From: Simon Davis
Sent: 03 July 2018 16:53
To: 'Lee Duggin'
Subject: AL/67/18/PL Land West of Fontwell Avenue (middle plot)

APPROVED SITE PLAN 1:500

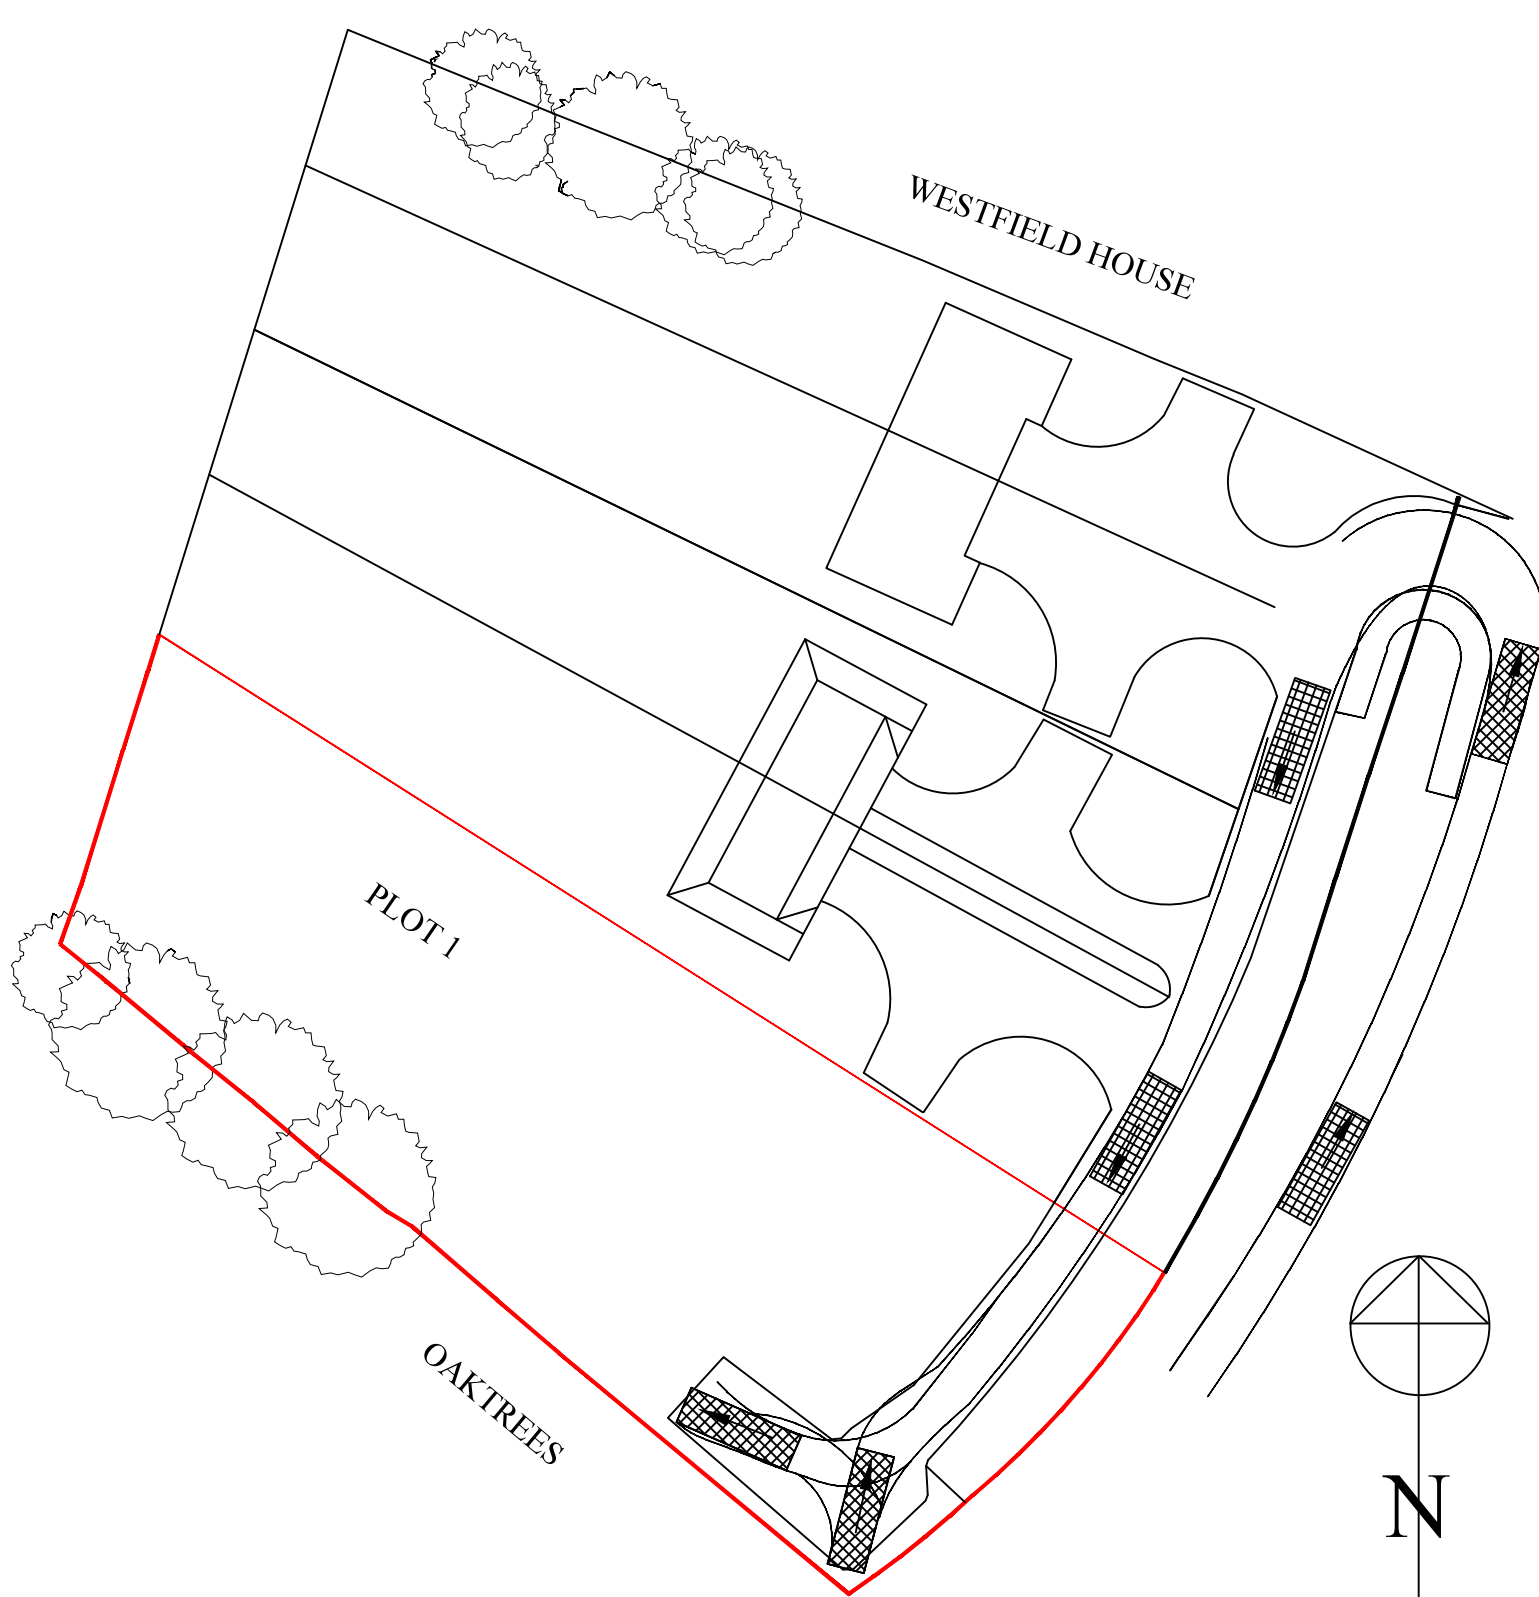
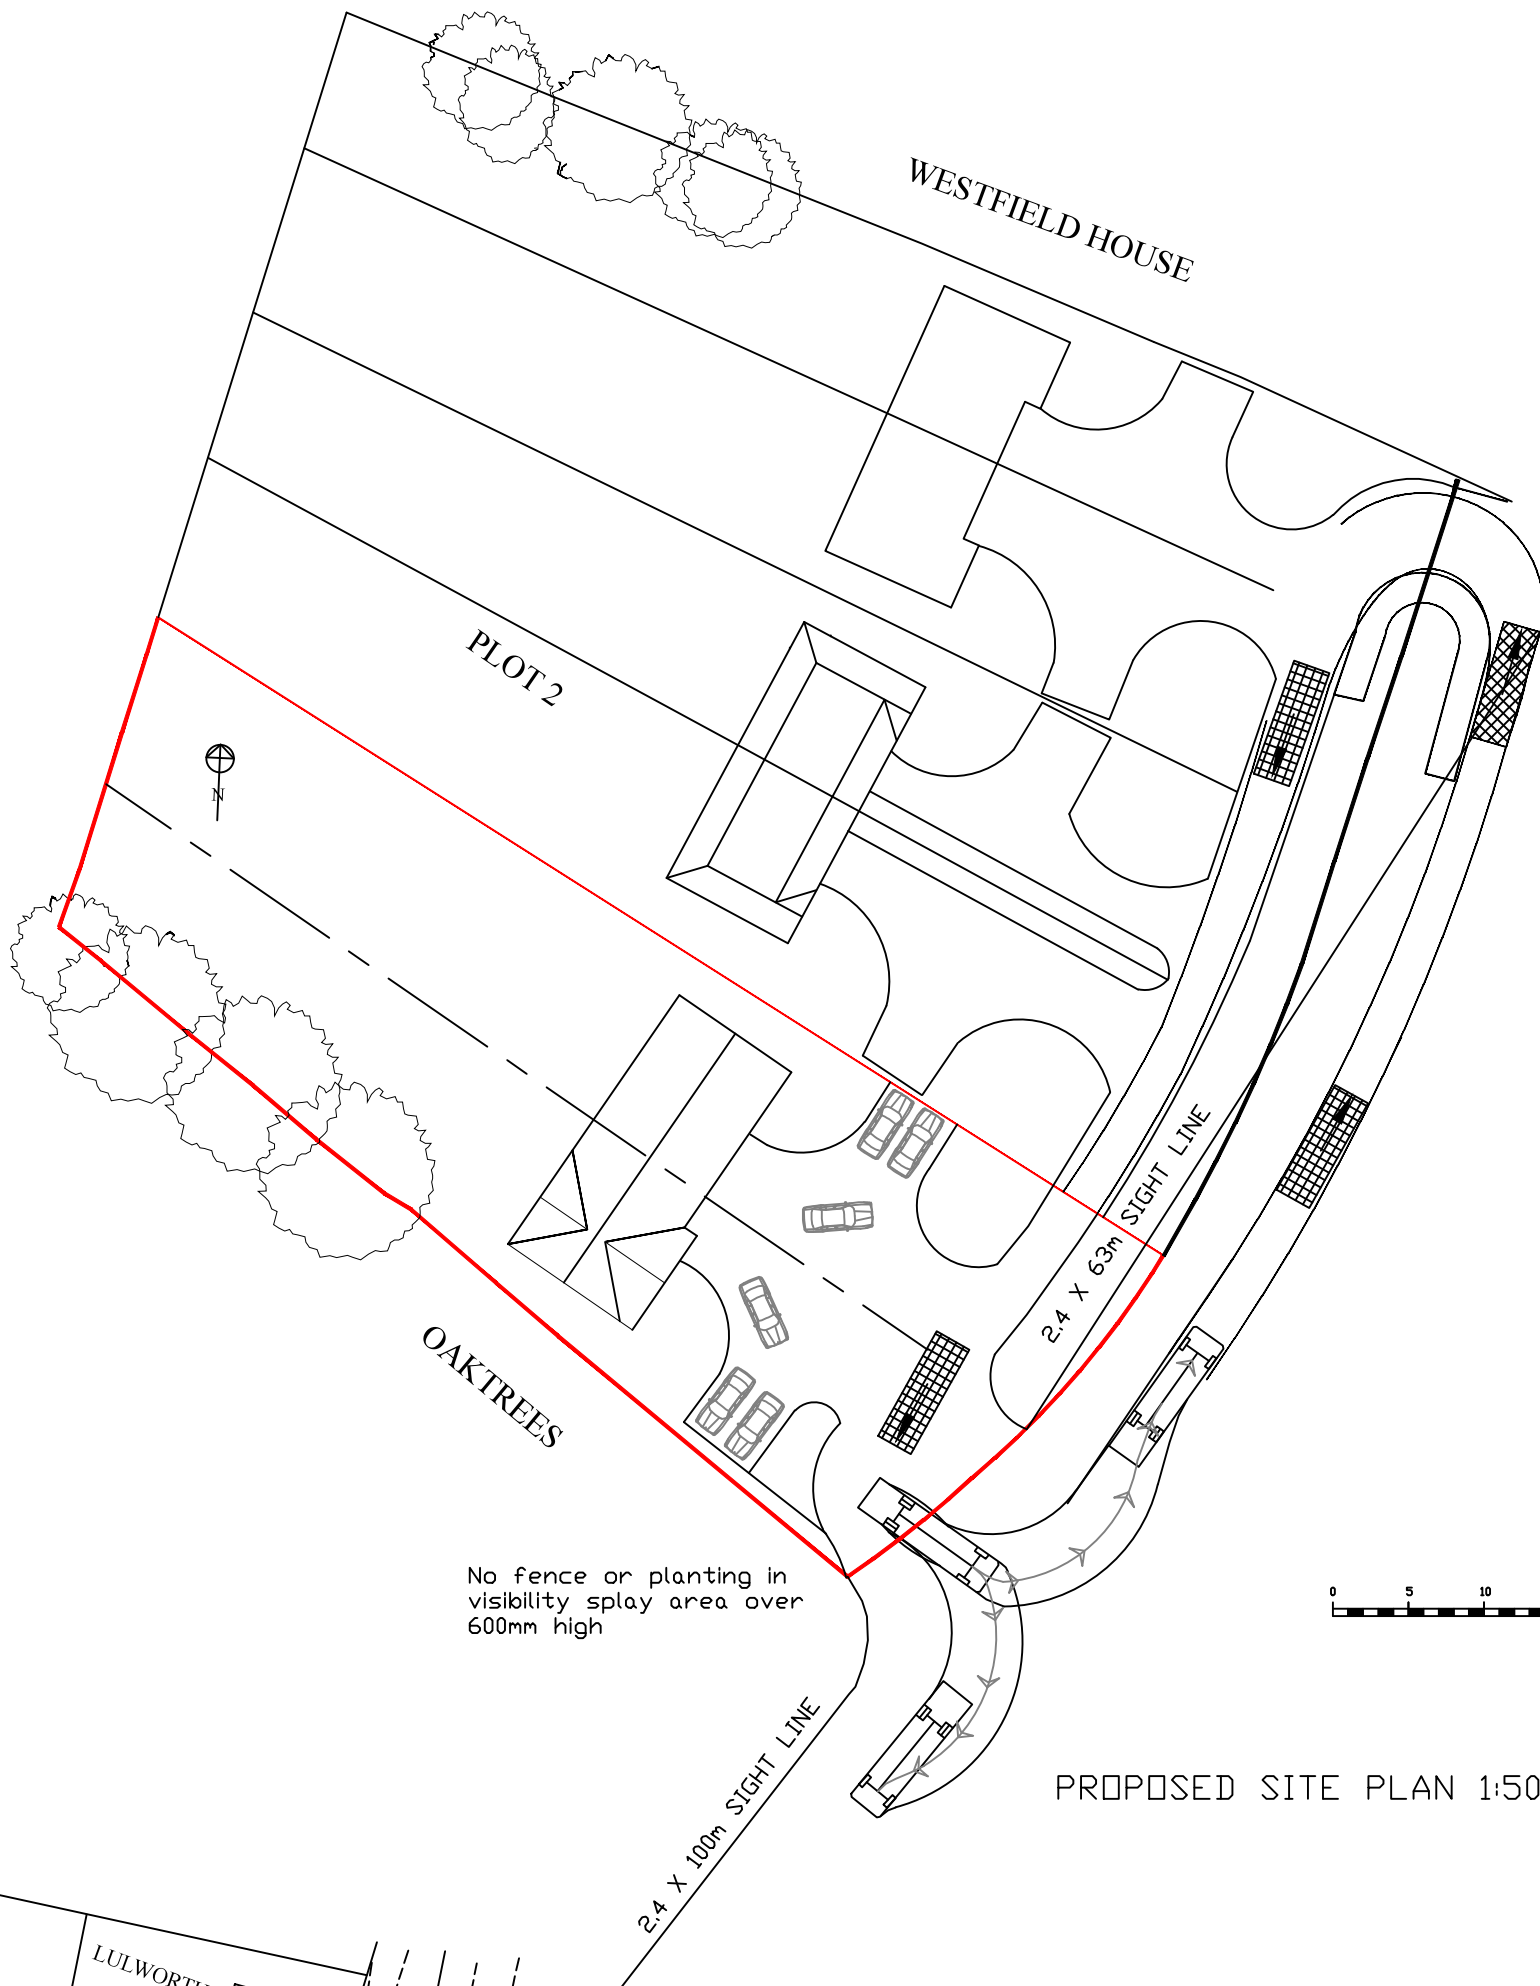
You have effectively applied to remove condition 06 of AL/122/17/PL but we cannot do this as this would mean then that you would not need to have the access shown on the approved drawing (the access at the northern end) implemented before you occupy the dwelling. This would result in an unsatisfactory situation. Therefore, this application would be refused.

I had assumed that your issue was that your approved plans show the large vehicle turning area at the southern end of the new internal drive and you would not be able to comply with condition 08 (parking & turning) of AL/122/17/PL because if AL/136/17/PL is approved with the new access, then this would not be provided. However, this would not matter as that large vehicle turning area is not within your red edge and as such condition 08 only requires you to provide the parking & turning facilities within the applicant's part of the site.
